Second Submissions Report

Infill Affordable Housing

2 - 16 Pockley Avenue, Roseville

SSD-77825469

1 Building Section B - Pavilion C
 SCALE 1 : 200

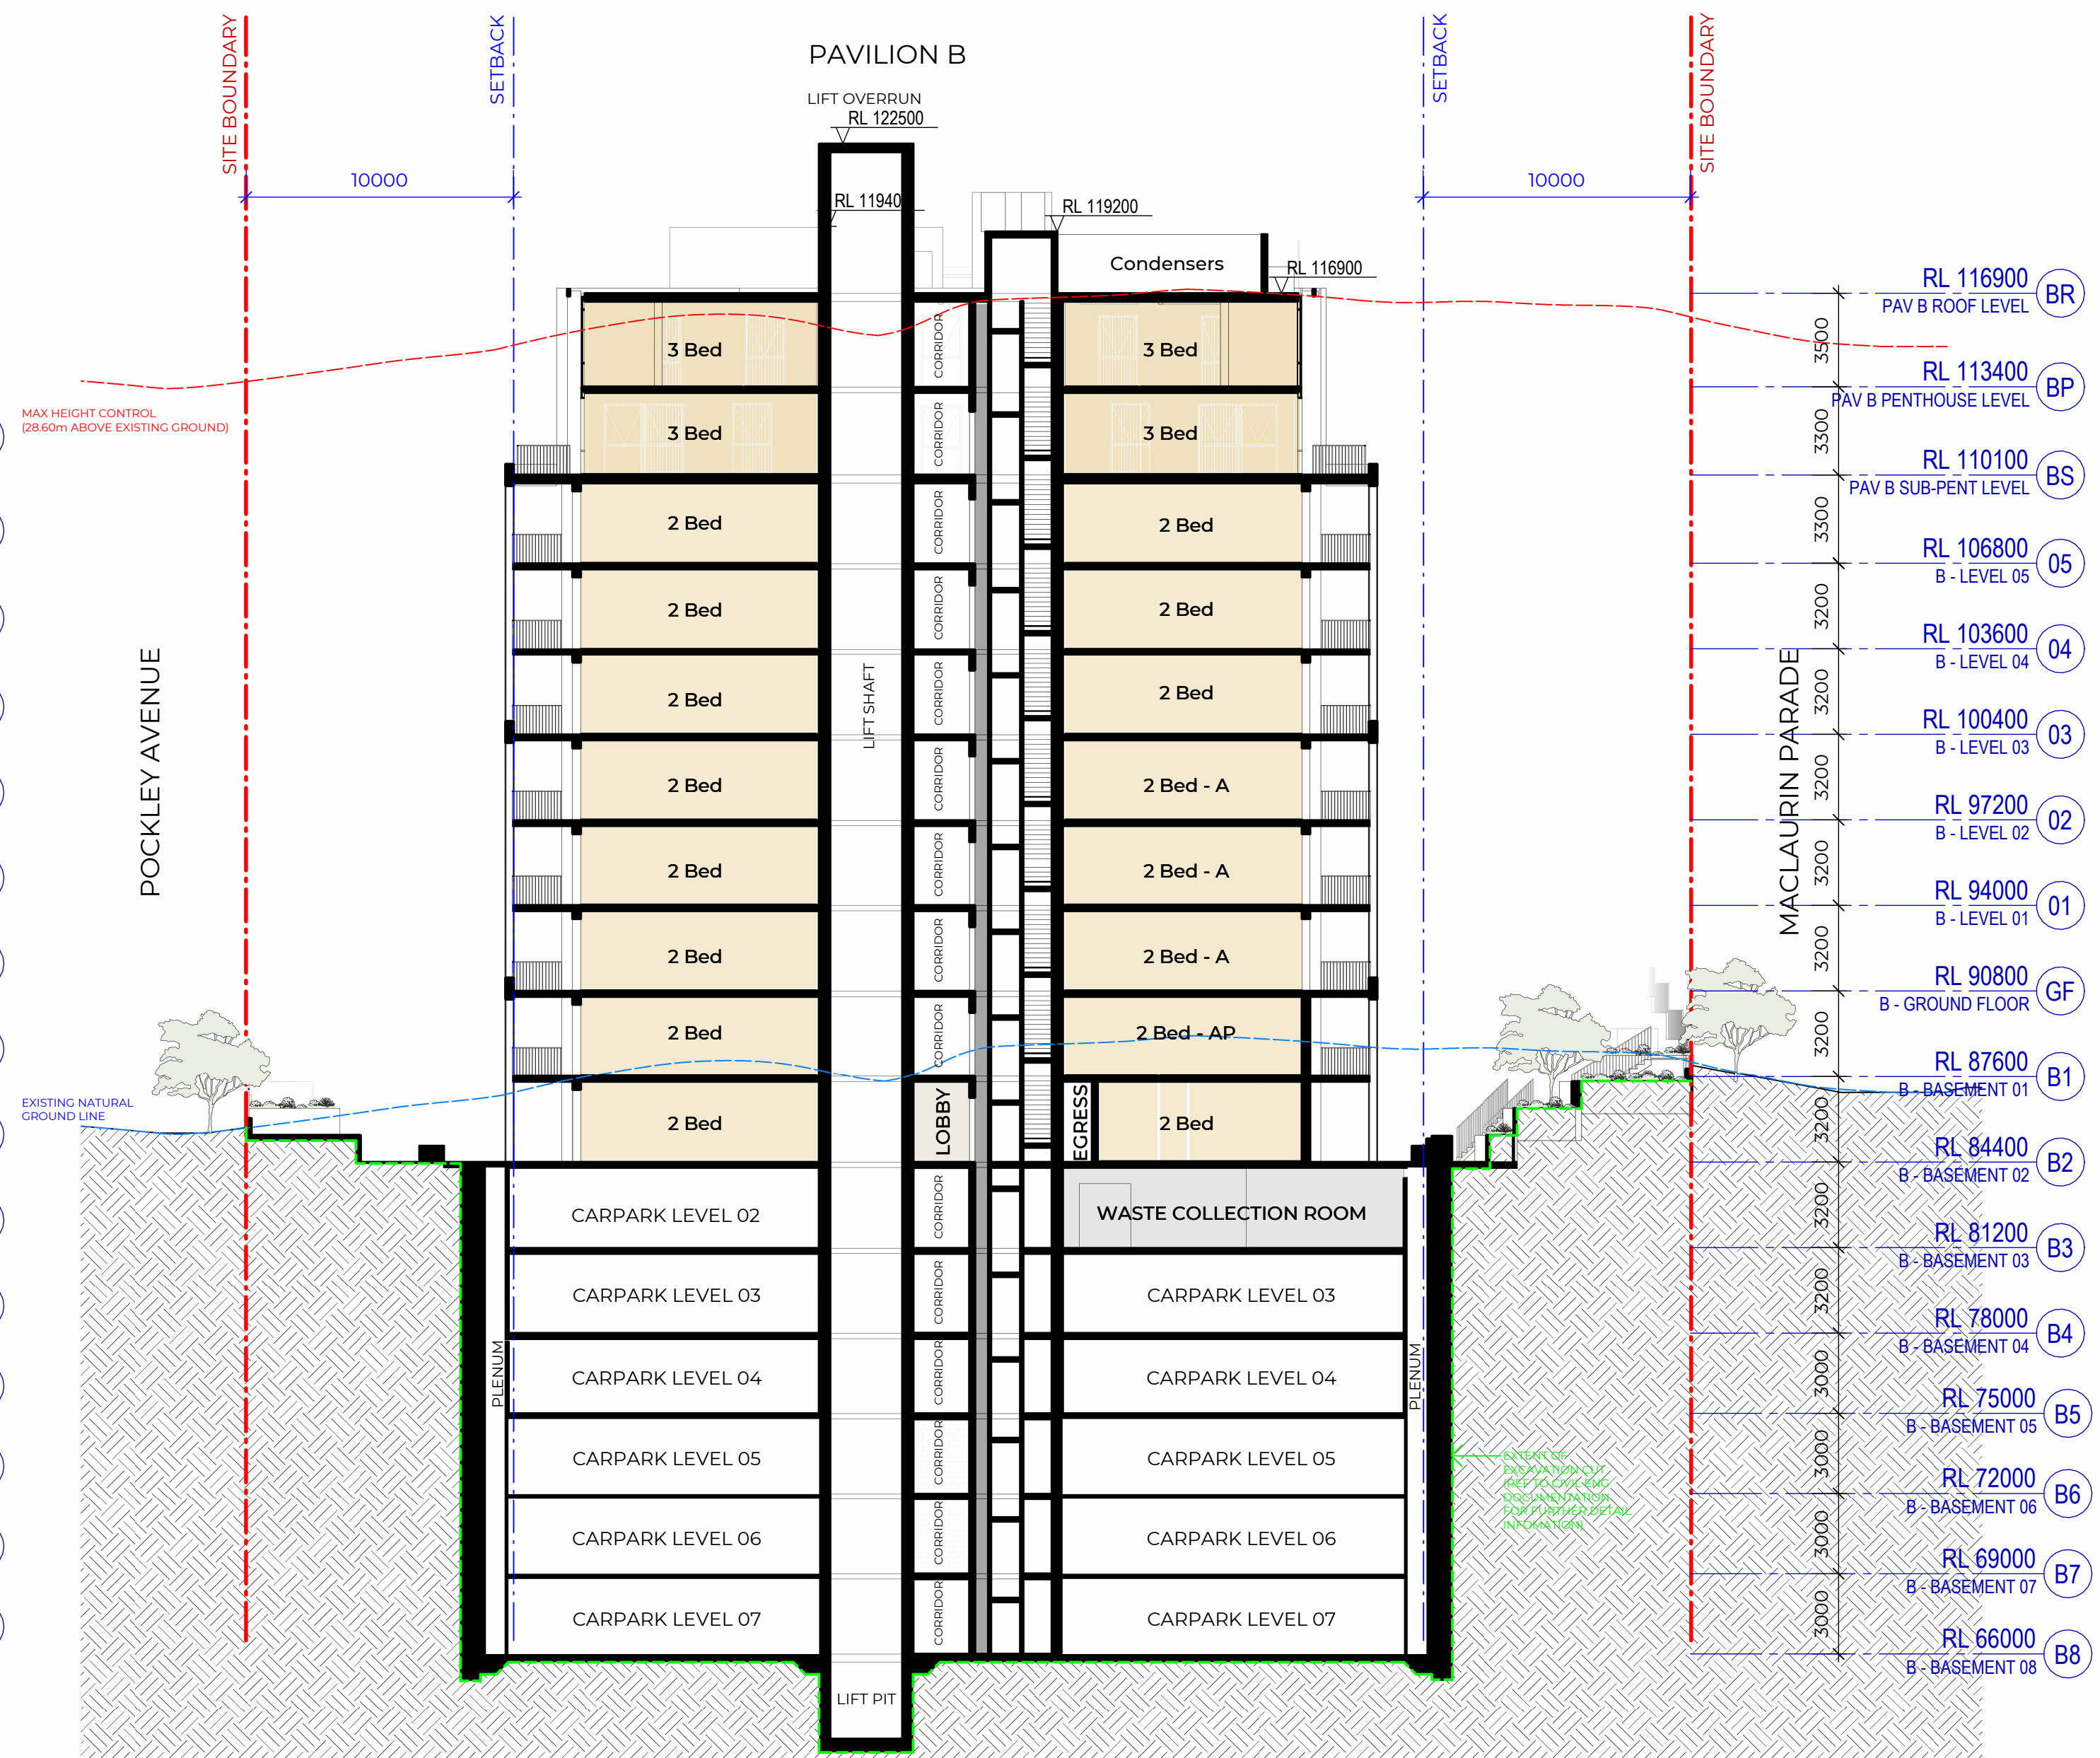
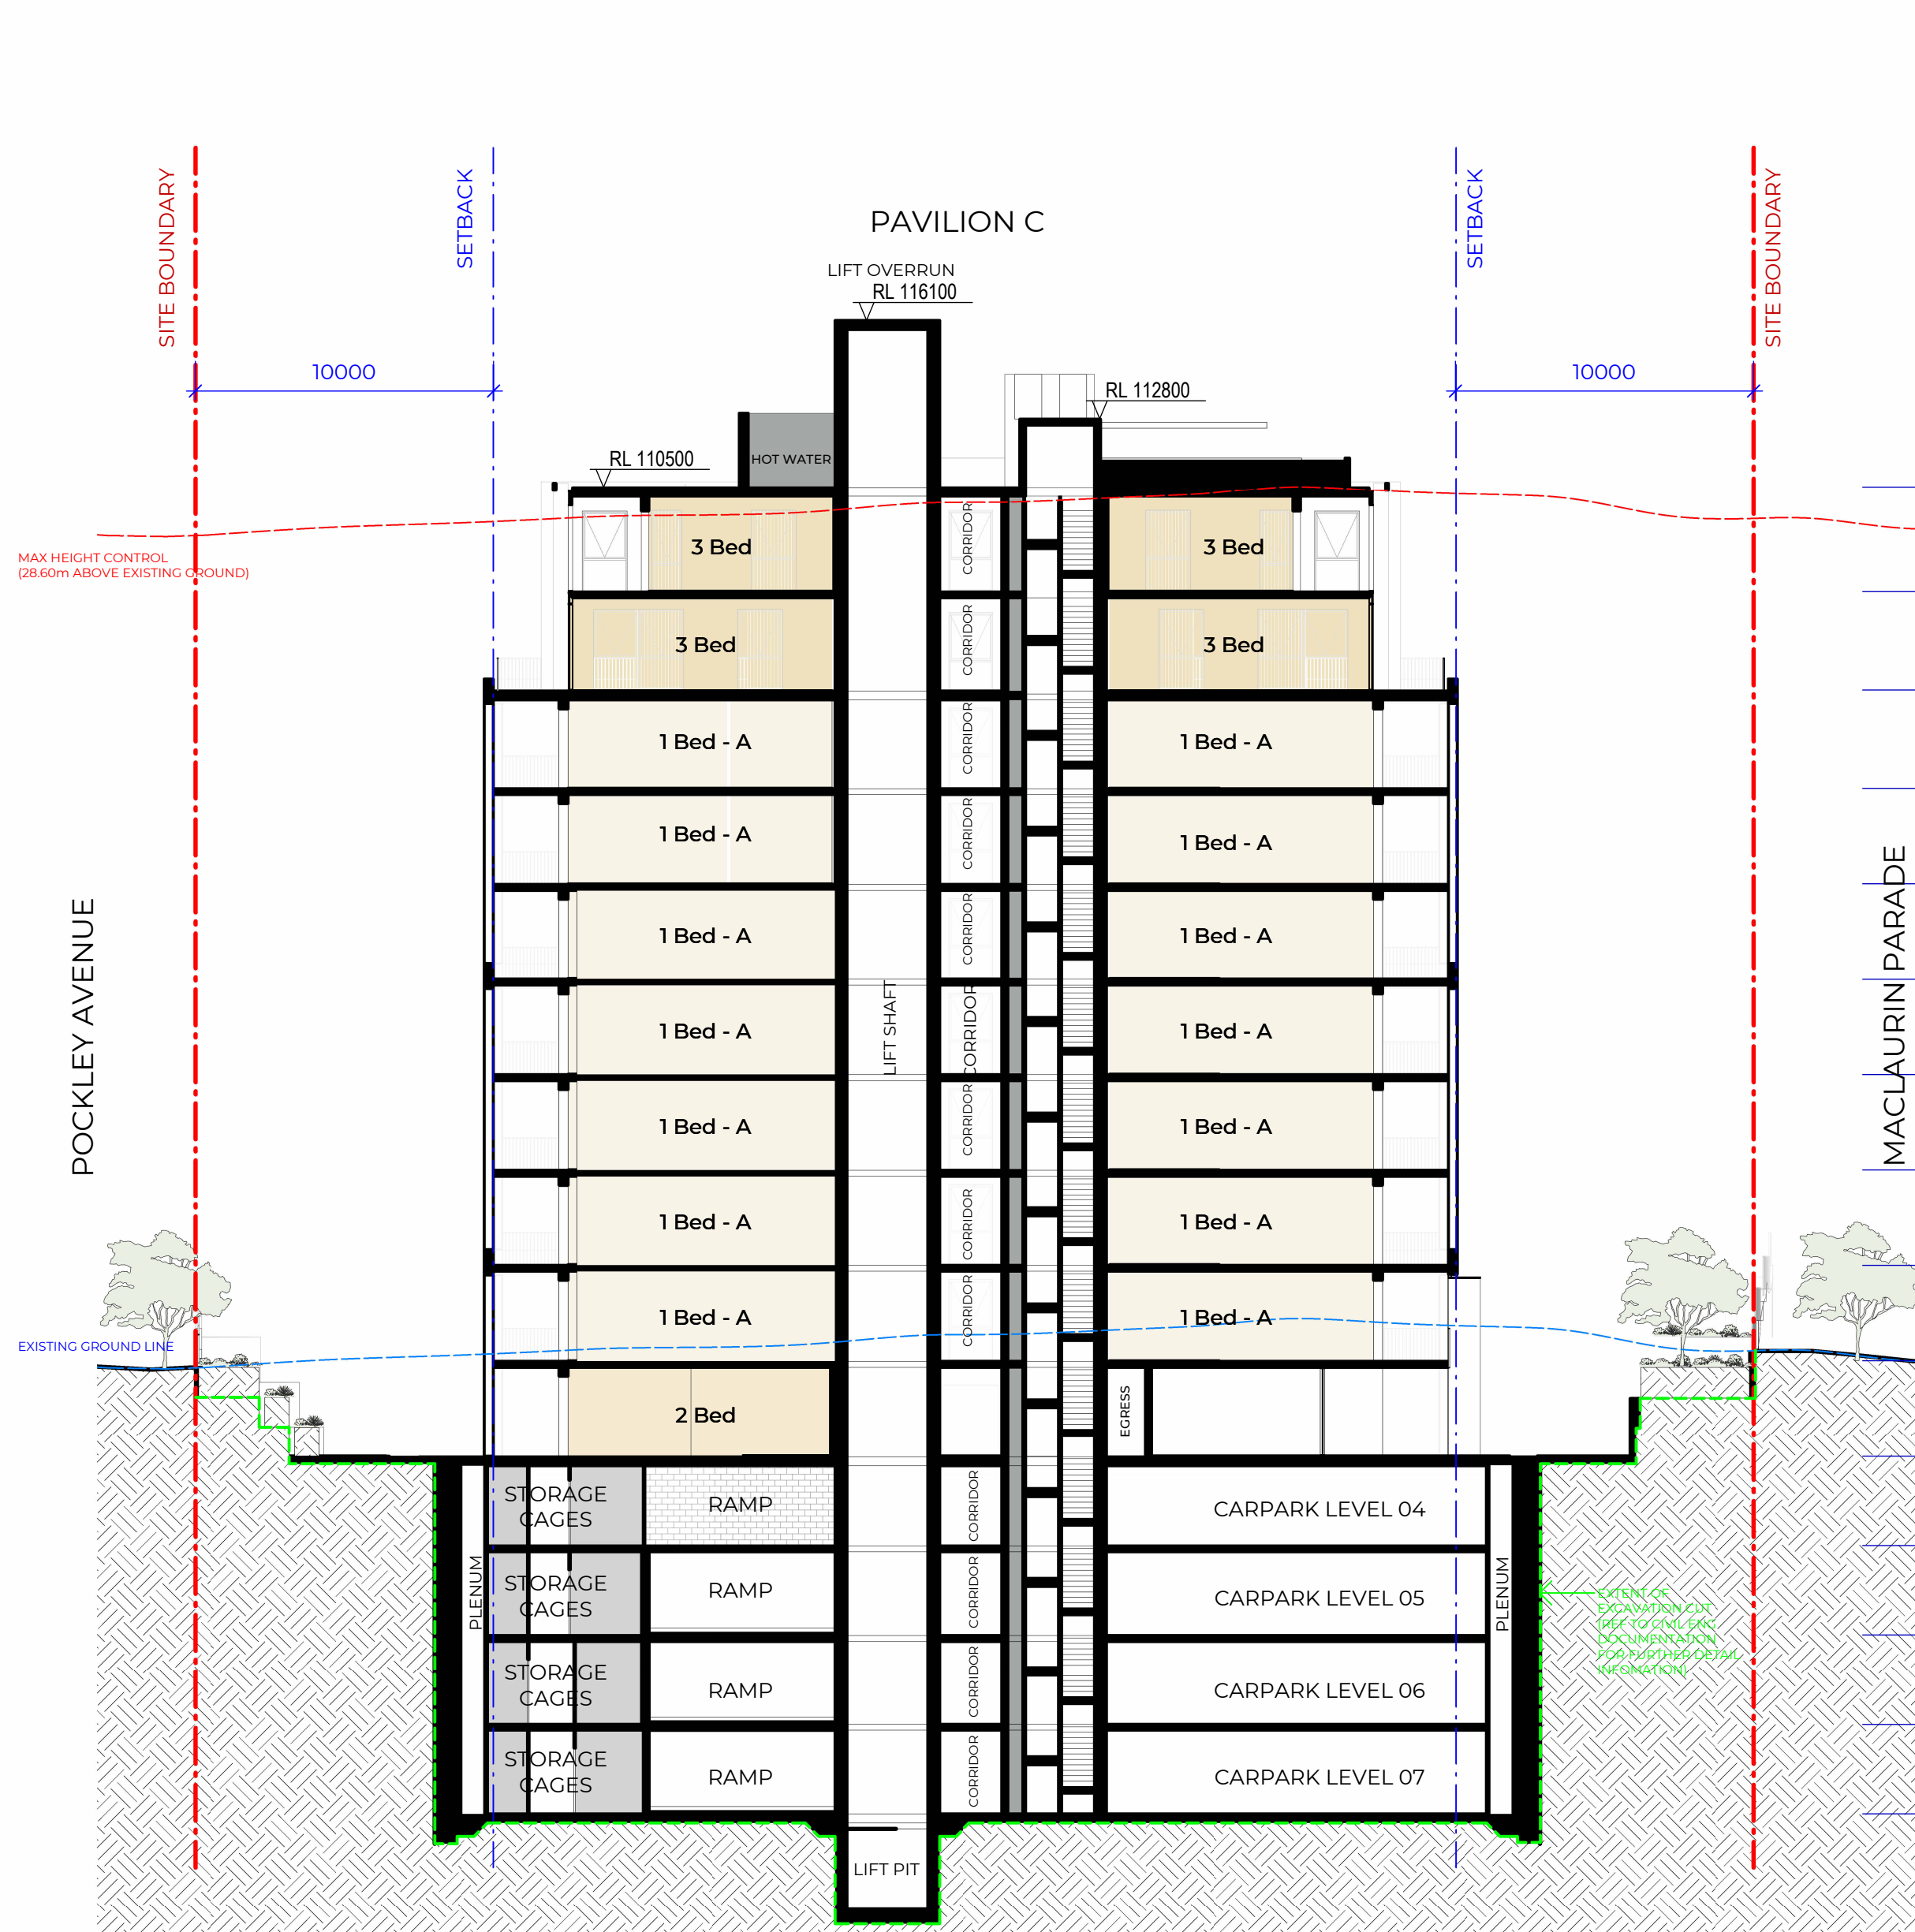
Built form and scale		
2	The Combined Submissions Amendment Report (Report) references Building Sections E and F in the revised Architectural Plans. These drawings cannot be located in the drawing set provided nor are they listed in the Drawing List. As noted above, consideration of alternative siting work undertaken with SDRP is noted and accepted. The key concern (relating to vertical depth of the courtyard POS and COS spaces) has not been addressed. Nor does applicant's response address how a reduction in yield would help resolve the issue and produce better amenity outcomes. The proposed bulk and height increase compounds problems identified previously.	- Sections through Communal Open Space and Streets are highlighted in drawings 'DA-AR-B-32-004_Building Elevations - Pavilion B and C East', and 'DA-AR-B-32-005_Building Elevations - Pavilion A and B West'. - The proportions of the courtyard POS ensures that all courtyard POS spaces have adequate high level of amenity, privacy and security as well as an outlook to a landscaped terracing wall, and to the sky. - The increase in building heights do not have any impact to sunlight access between building blocks.

STUDIO_01			
Name	Area	Storage Volume	Silver LHA
POS	5 m²	6.0 m³	Yes
Studio - AP	41 m²

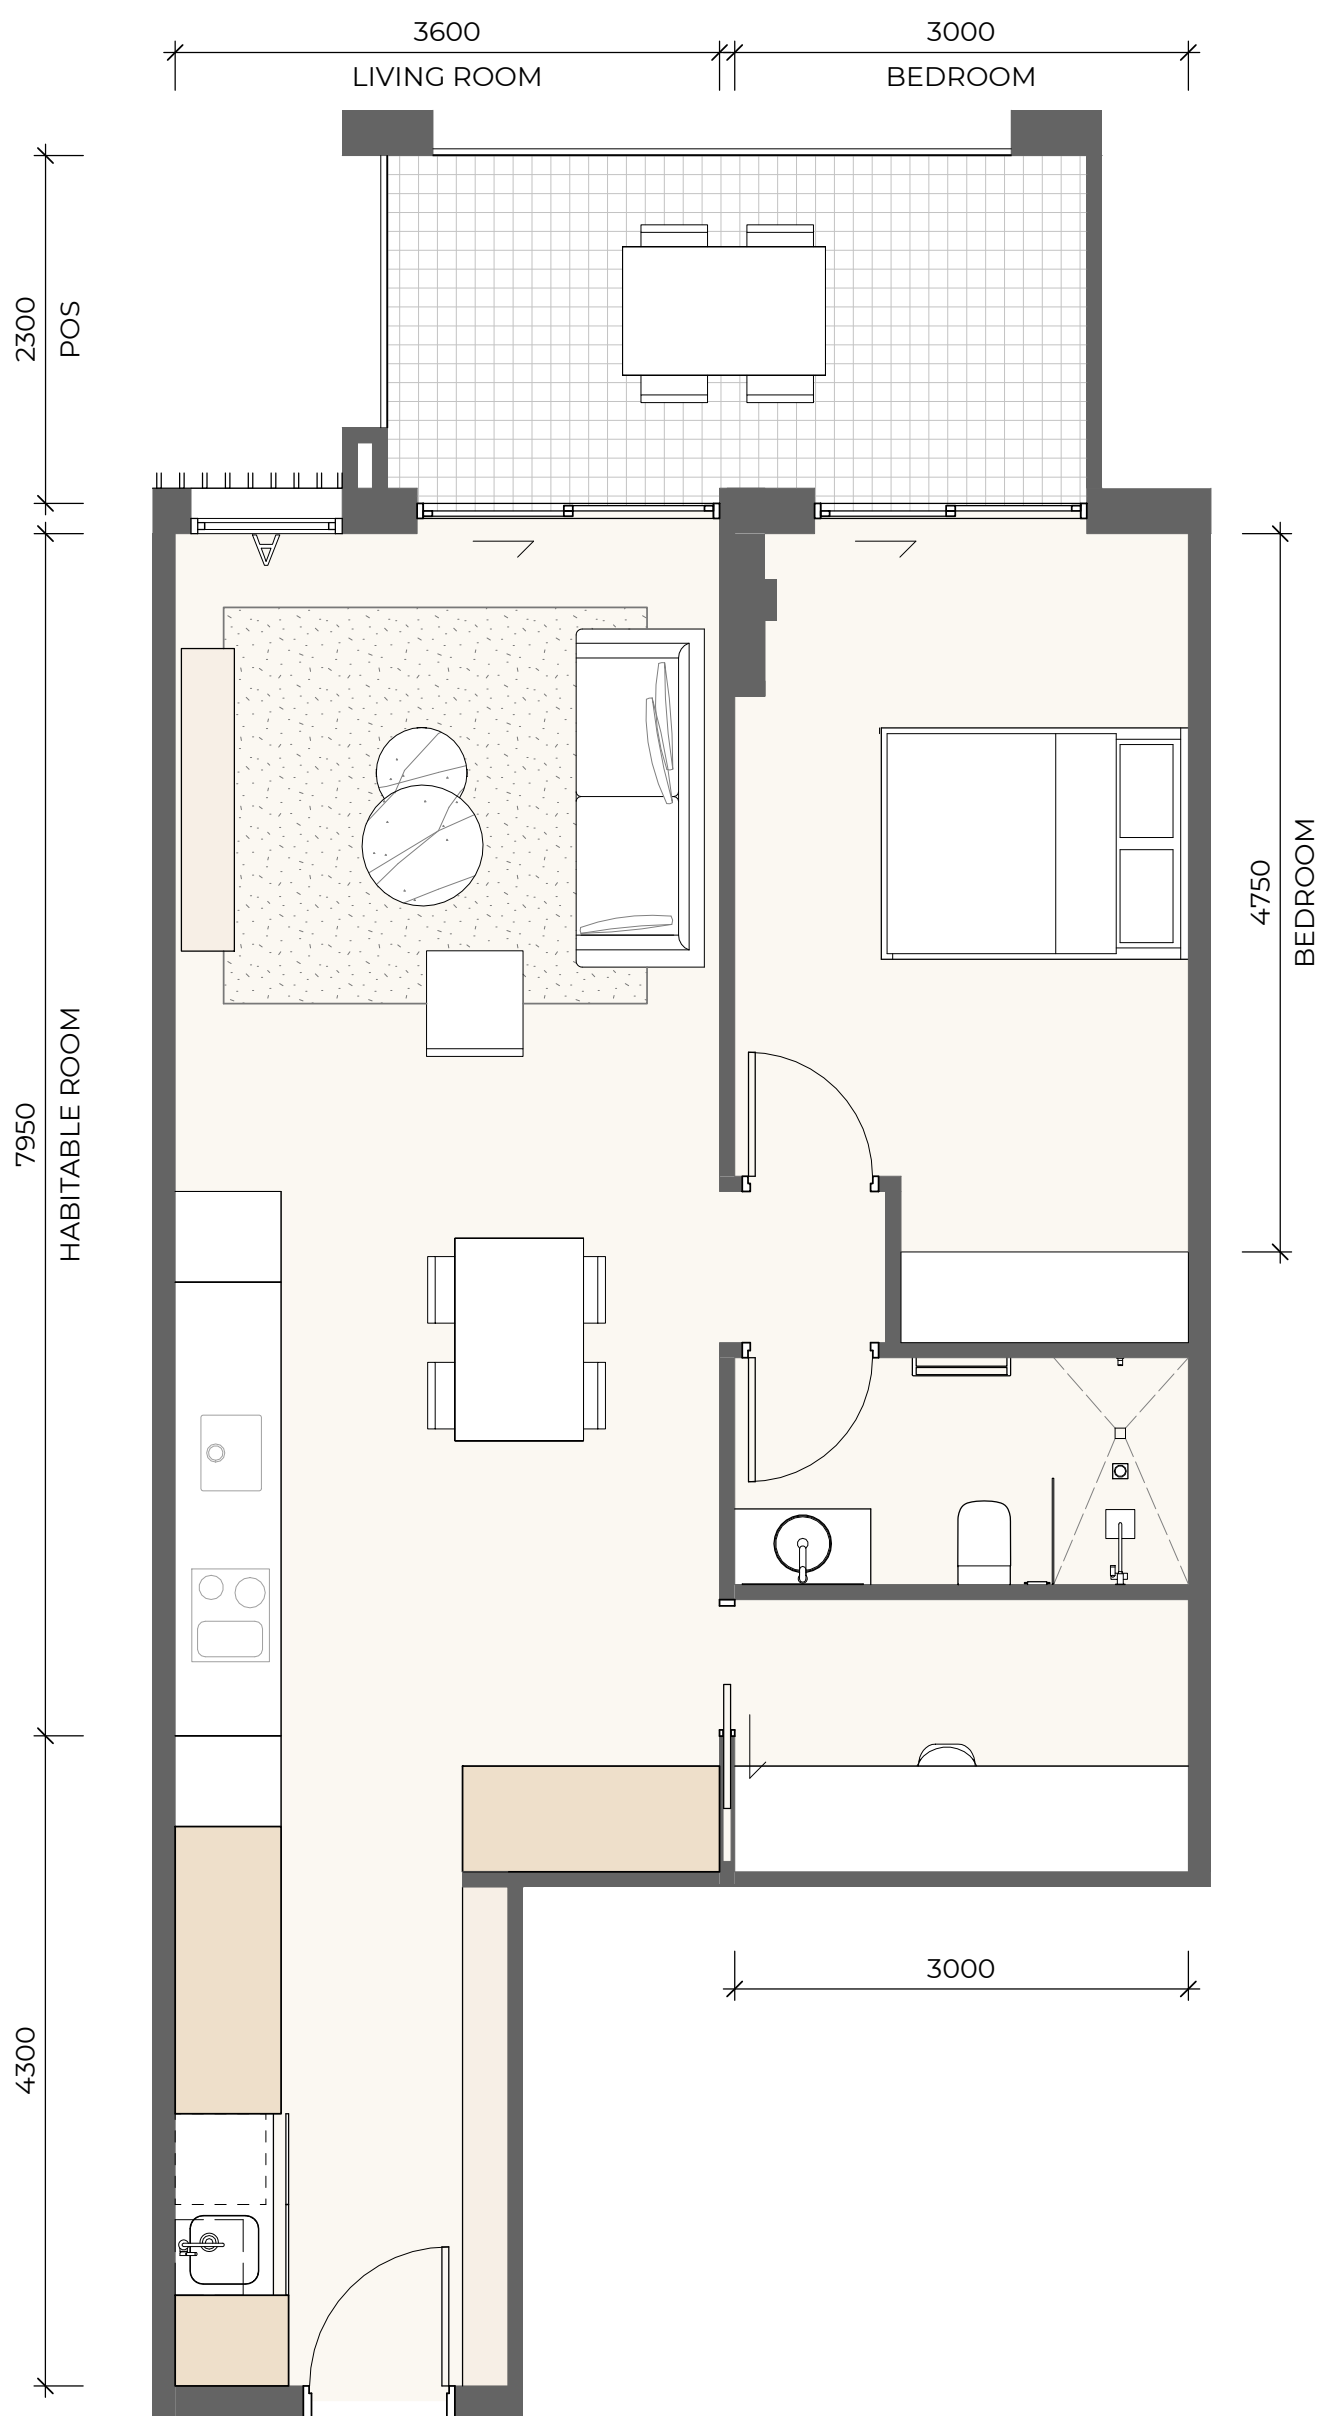
7	<i>B-81-001 – Unit types – Studio & 1 Bedroom</i> <i>Studio apartment layout shows depth of living room to be 8 m. The bedroom is located beyond this depth and has no opening. While this is a studio, a full height partition is proposed to the bedroom which will result in a room with no sunlight access. This apartment is also proposed to be used as an affordable apartment and the Apartment schedule in the Design report indicates that the depths comply.</i> <i>We will need some justification regarding the layout of the studio apartment and how the bedrooms will function.</i>	The studio apartment living space depth is only 5.5m deep to the bedroom area. The width of the opening between these two spaces is the entire width of the corridor and these dimensions are less than the maximum depths provisioned in the ADG.
